**SSD 8636: ENGINEERING & TECHNOLOGY PRECINCT DEVELOPMENT
UNIVERSITY OF SYDNEY, DARLINGTON CAMPUS**

UNIVERSITY OF SYDNEY RESPONSE TO SUBMISSIONS

21 SEPTEMBER 2018

Level 6, 155 Clarence Street,
Sydney, NSW 2000, Australia
T + 61 2 9267 9599
F + 61 2 9264 5844
www.coxarchitecture.com.au

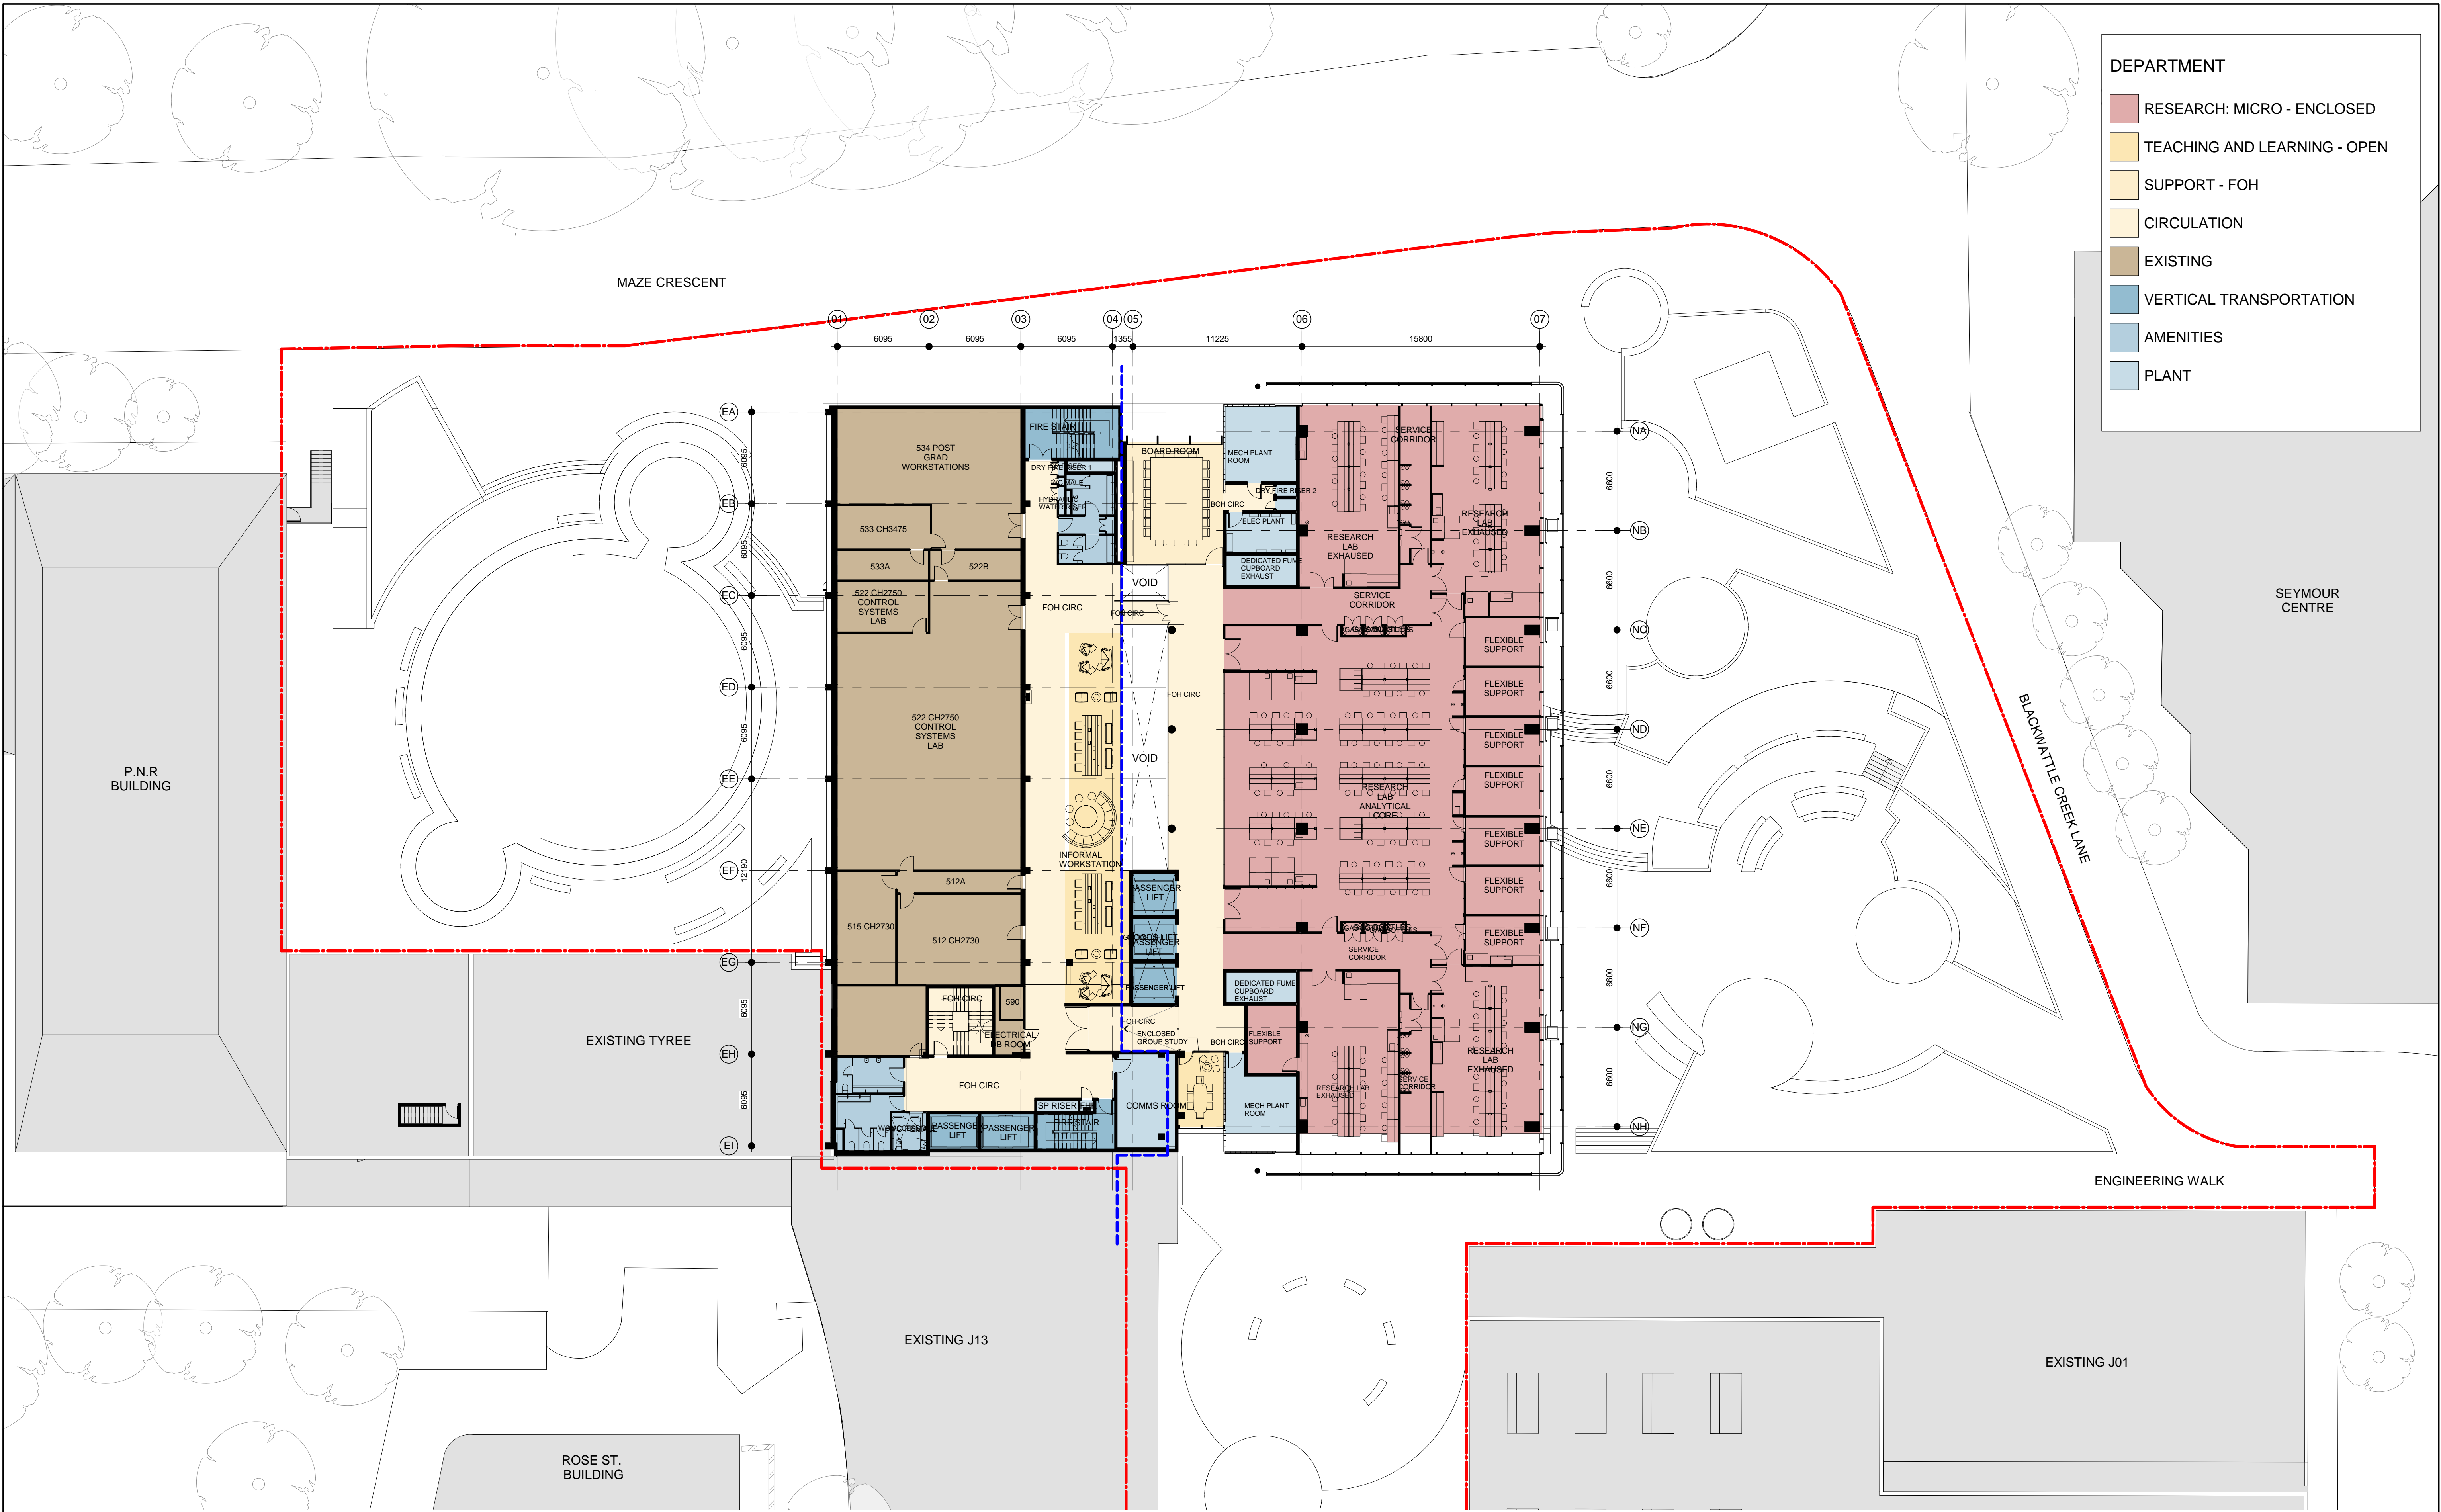
A-DA-2102	FLOOR PLAN - LEVEL 02	D	<ul style="list-style-type: none"> End of trip facilities (2 showers) added Updated bike rack count Deletion of engineering walk awning Addition of risers along grid 06 	<ul style="list-style-type: none"> 3.14 - End of trip facilities 1.06 - End of trip facilities
A-DA-2103	FLOOR PLAN - LEVEL 03	D	<ul style="list-style-type: none"> Updated stair at western end Deletion of the portals and engineering walk awning Landscaping updated Risers added along grid 06 	
A-DA-2104	FLOOR PLAN - LEVEL 04	D	<ul style="list-style-type: none"> "Interconnecting accommodation stair" annotation added "& School hub" added to the name of room name 448 Department filled region extent amended to suit floor plate Landscaping updated 	
A-DA-2105	FLOOR PLAN - LEVEL 05	D	<ul style="list-style-type: none"> Department filled region extent amended to suit floor plate Riser along grid 06 added Landscaping updated

<ul style="list-style-type: none"> • Coordination between existing and proposed pedestrian links have not been demonstrated by the application. 	<p>Pedestrian links coordination forms part of the University of Sydney Campus Improvement Program (2014 – 2020) Access Strategy, coordinated and delivered by the University of Sydney.</p> <p>The Strategy reinforces the pedestrian priority routes within the campus being along Maze Crescent and Blackwattle Creek Lane.</p> <p>It is considered that implementation of traffic management treatments proposed in appendix I and via the implementation of Traffic Management Arrangements will adequately mitigate safety concerns and will not lead to poor pedestrian amenity.</p> <p>Reference to Appendix D1, section 3B) Blackwattle Creek Lane and Shepherd Street traffic/pedestrian upgrades, page 3-4 and Appendix D2 for further clarification</p>
<ul style="list-style-type: none"> • End of Trip facilities including separate staff and student bicycle parking in an accessible on grade location are not clearly identified in the proposal. 	<p>End of trip facilities have been calculated and provided in accordance with the Sydney DCP 2012. Refer to Appendix A, page 7, drawing number A-DA-2102</p>

2 LEVEL 12  
SS  
A-DA-2112 SCALE 1 : 200

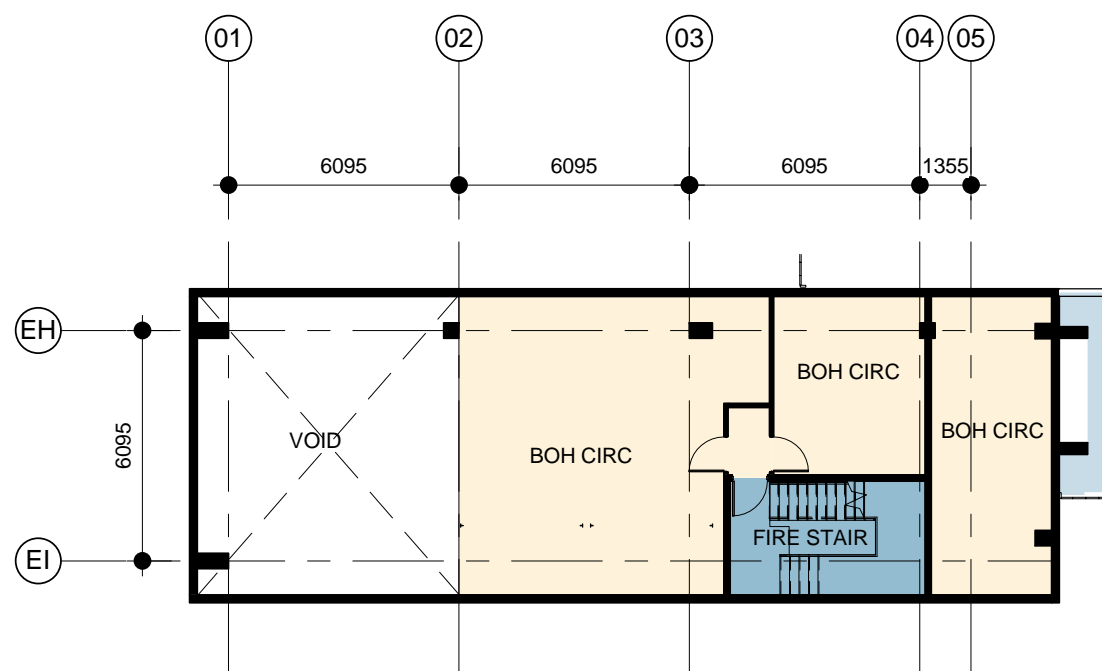
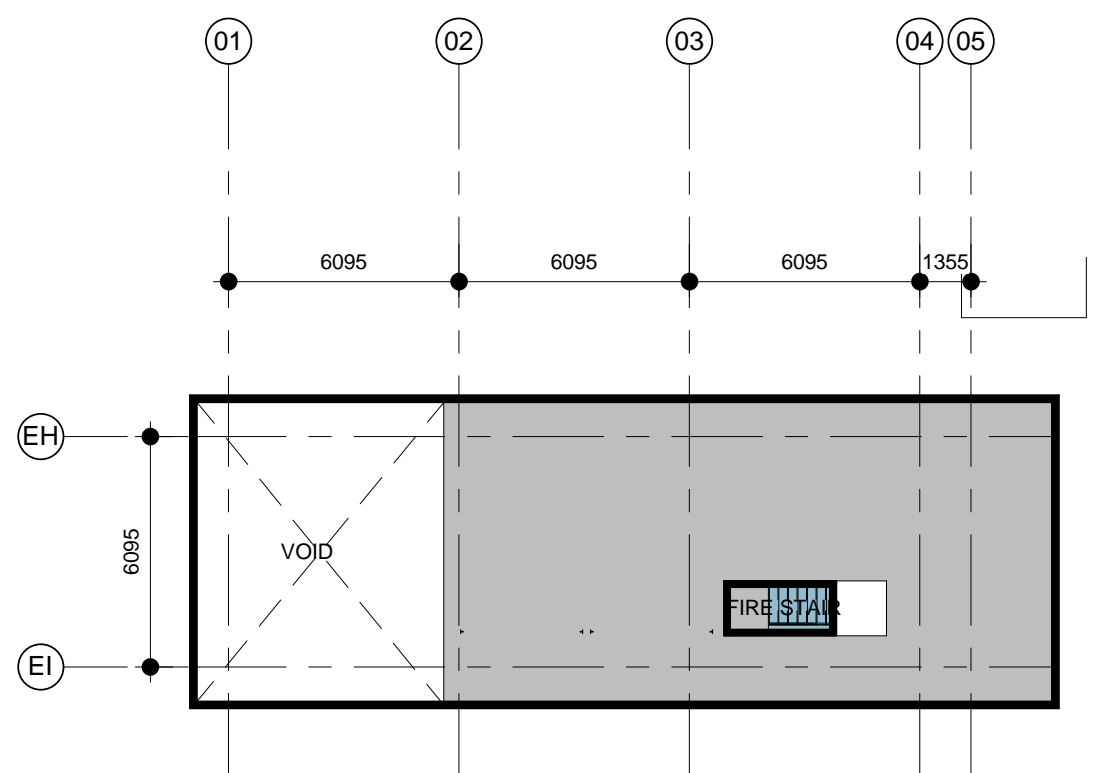
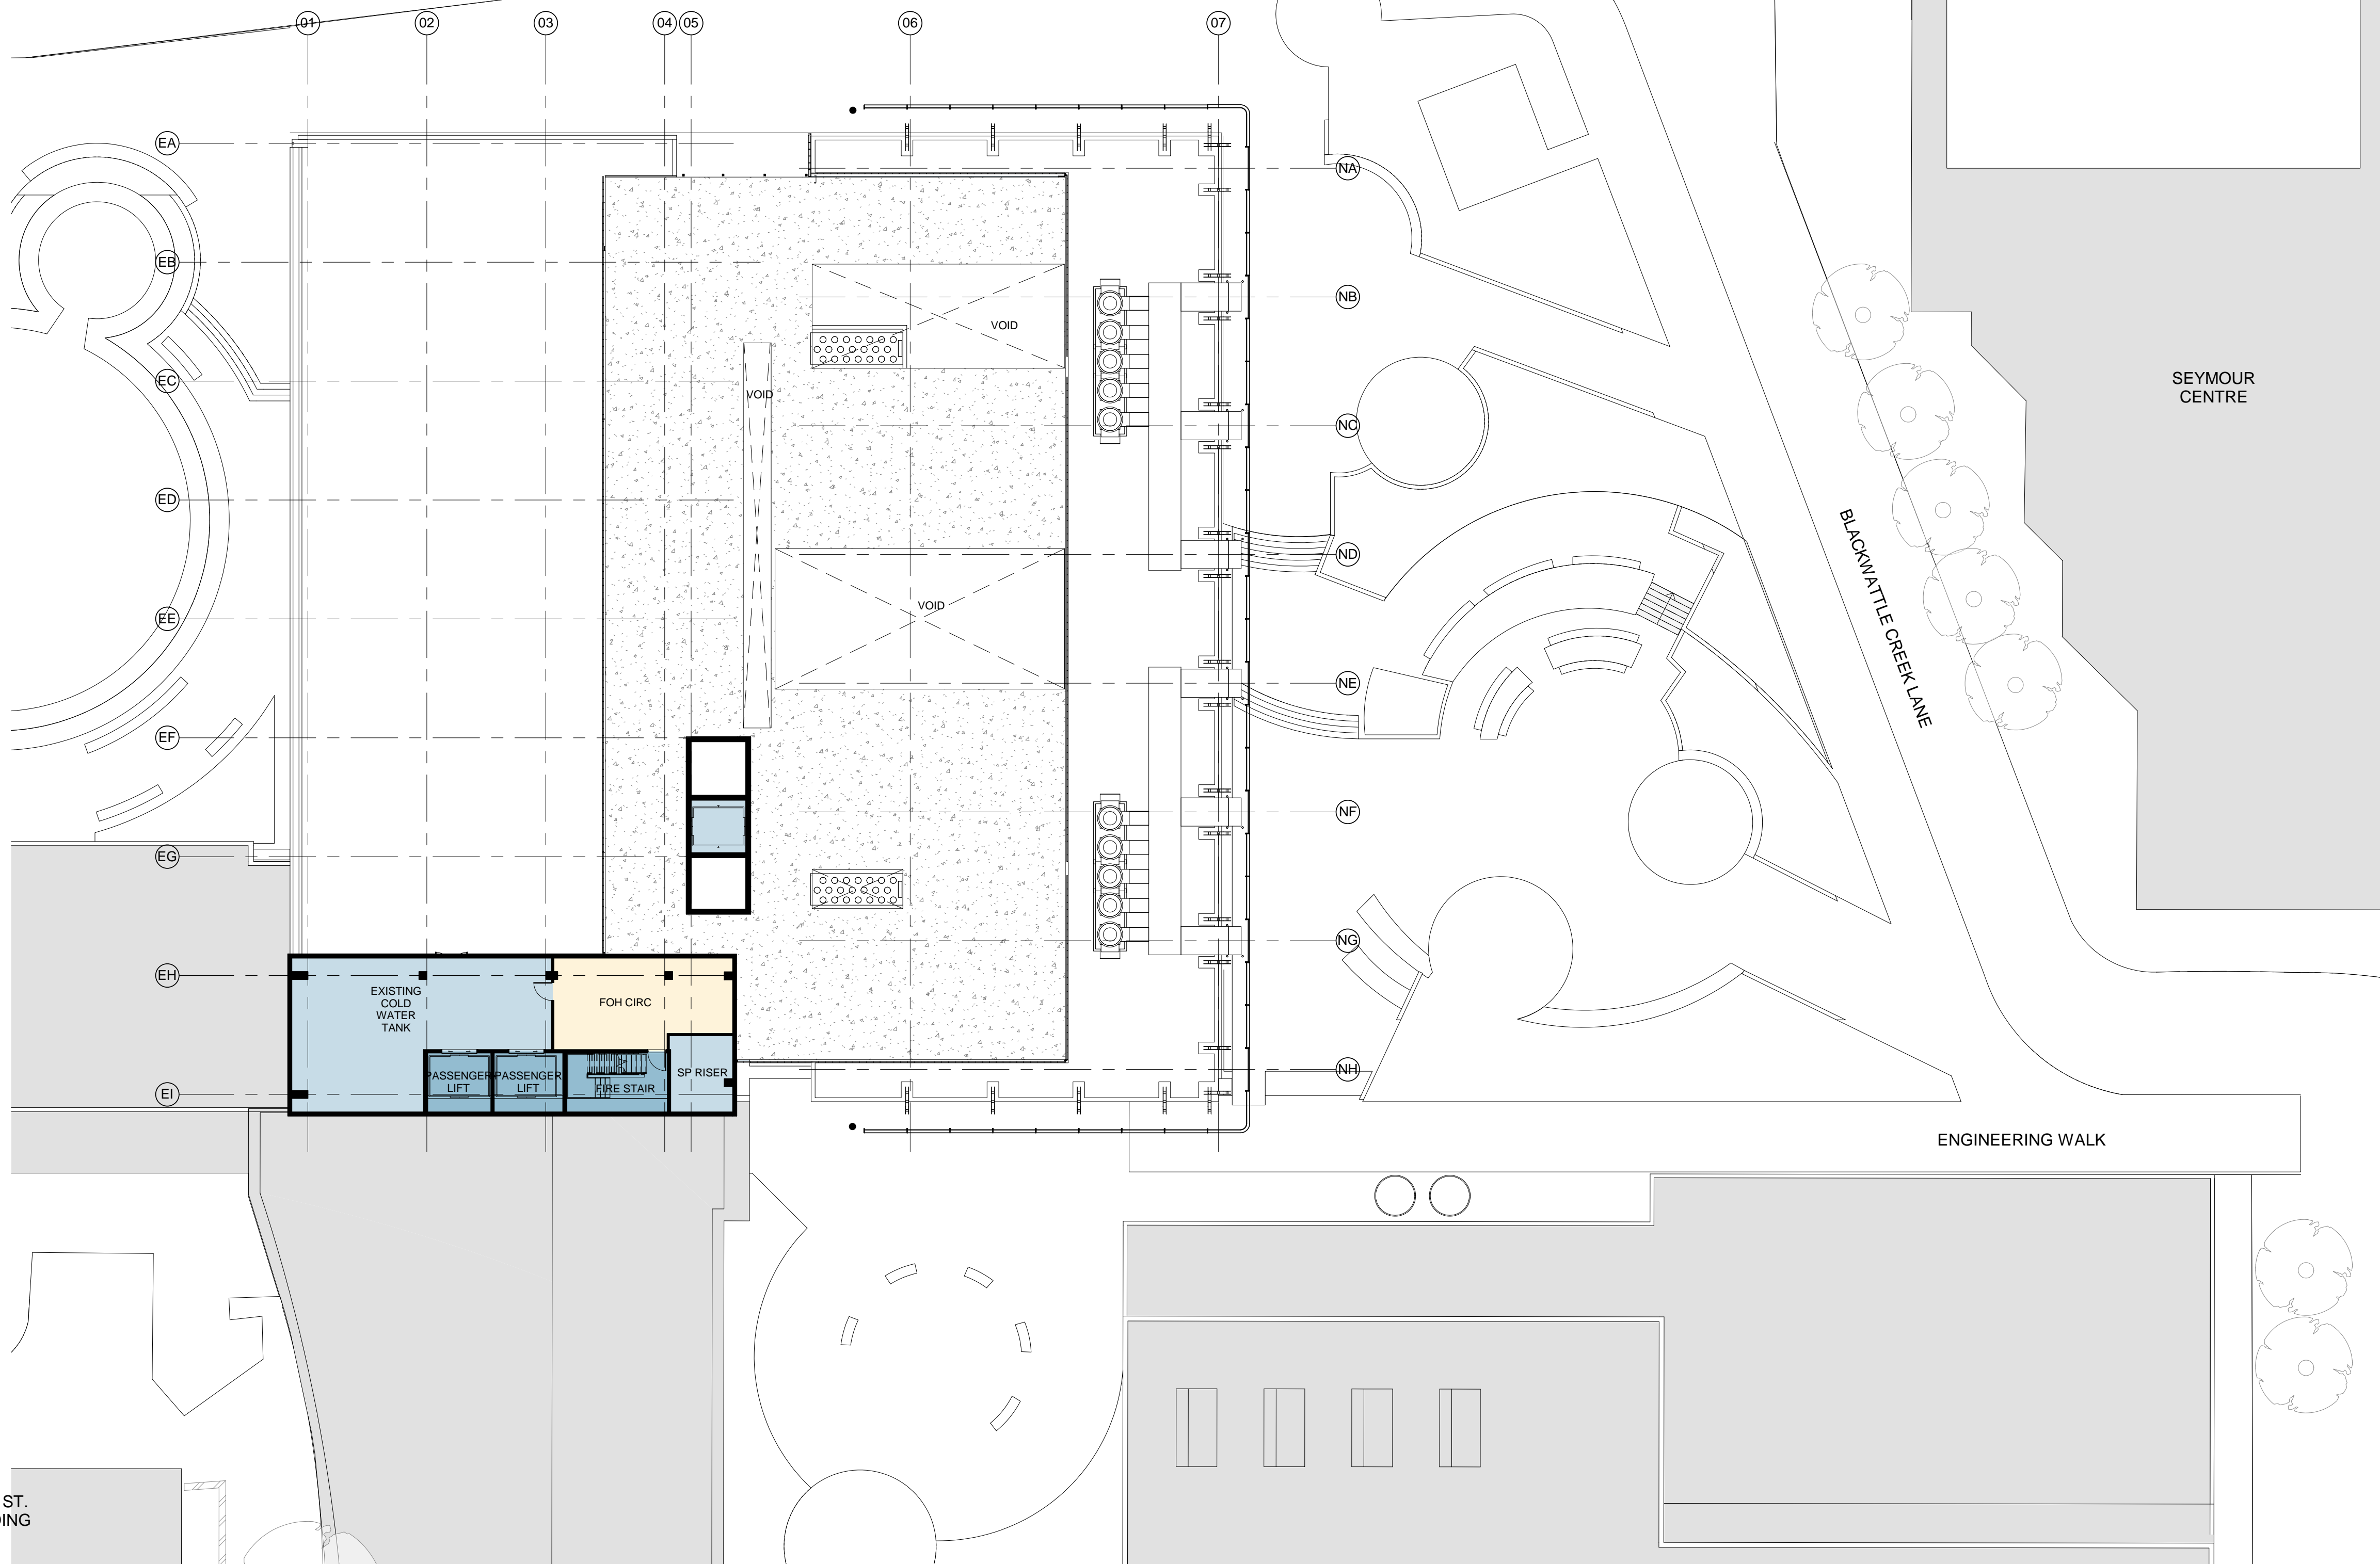
4. ESD <ul style="list-style-type: none"> The proposal indicates a clear intent to install renewable energy systems on the roof such as photovoltaic arrays and solar water heating panels, which is supported by the City. The Department are advised to request that the plans show clearly where these systems will be accommodated. 	PV panels will be installed on the roof as per the roof plan below.

A-DA-2110	FLOOR PLAN - LEVEL 10	D	<ul style="list-style-type: none"> Stair along grid NG relocated 	
A-DA-2111	FLOOR PLAN - LEVEL 11,12,13	D	<ul style="list-style-type: none"> Roof geometry amended Solar panel array added Hot water panel array added 	<ul style="list-style-type: none"> 3.10 ESD
A-DA-3001	NORTH ELEVATION	D	<ul style="list-style-type: none"> Landscaping updated Engineering walk awning deleted In the legend, "polycarbonate panel" replace by "glass plank" 	
A-DA-3001A	3D VIEW - NORTH	B	<ul style="list-style-type: none"> 3D view replaced 	
A-DA-3002	SOUTH ELEVATION	D	<ul style="list-style-type: none"> Feature screen amended and added Glass plank deleted and replaced by full height curtain wall 	
A-DA-3002A	3D VIEW - SOUTH WEST	B	<ul style="list-style-type: none"> 3D view replaced 	
A-DA-3003	EAST ELEVATION	D	<ul style="list-style-type: none"> Engineering walk awning deleted Part of glass plank replaced by curtain wall running full height
